**APPLICATION NUMBER 3/2013/0610
WITHGILL FARM, WITHGILL FOLD, WITHGILL, BB7 3LW
GRID REFERENCE 370823 441376**

A retrospective planning application has been submitted by Mr Alan Kinder of Avalon Town Planning Ltd on behalf of Mr D Barnes for the construction of a new earth banked slurry store/lagoon. A site visit was made on 5 September whilst the applicant's agent was present. The information provided at this meeting, together with the written submissions forms the basis of this appraisal.

Avalon Chartered Town Planning	
Town Planning - Architectural Design - Building Regulations - Surveying	
Phone: 01282 334834 Fax: 01282 451666 E-mail: info@avalonrpi.co.uk 2 Reading Business Centre, Redman Road, Bursley, Lancashire, BB10 2TV	
PROPOSED SITE PLAN

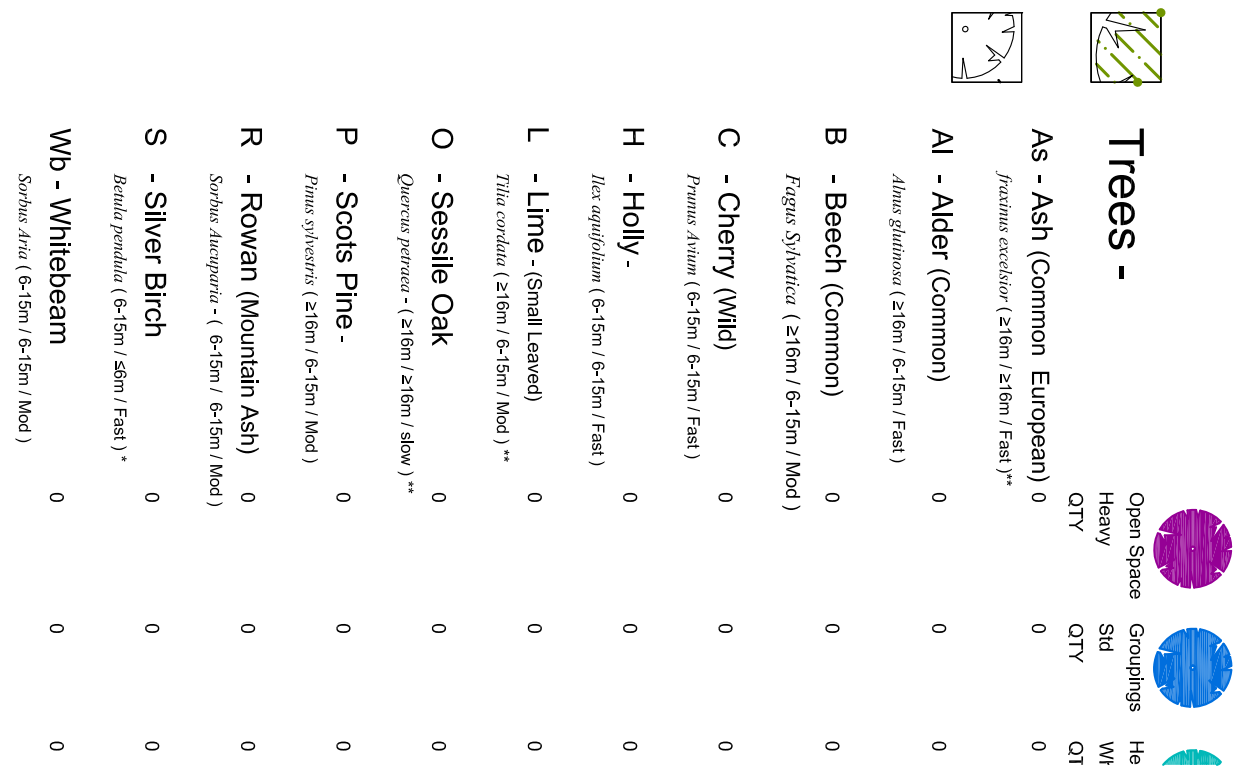
I was informed by the applicant's agent that the dimensions of the lagoon subject to this application are 90m x 75m x 5m and will hold approximately 30,205 cubic litres. When taking into account the lagoons that have been granted permission and the spare capacity required in order to empty the lagoons on a rotational basis, I consider that the lagoon, subject to this application is greater in size than strictly necessary, I do not however consider the size of the lagoon is excessive and consider that the volume of the proposed lagoon is proportionate to the applicant's herd size and operations.

In my opinion, consultation should be held with the Environment Agency on matters such as the siting and design of the lagoon, e.g. in connection to the soil permeability and whether the membrane is required, although I understand that contact with the EA has been made in this respect.

The slurry lagoon is situated next to the other earth banked slurry lagoon on the northern boundary of the farmstead. It is my opinion that the slurry lagoon is situated in an appropriate position in regards to the cattle accommodation buildings and from an operational point of view.
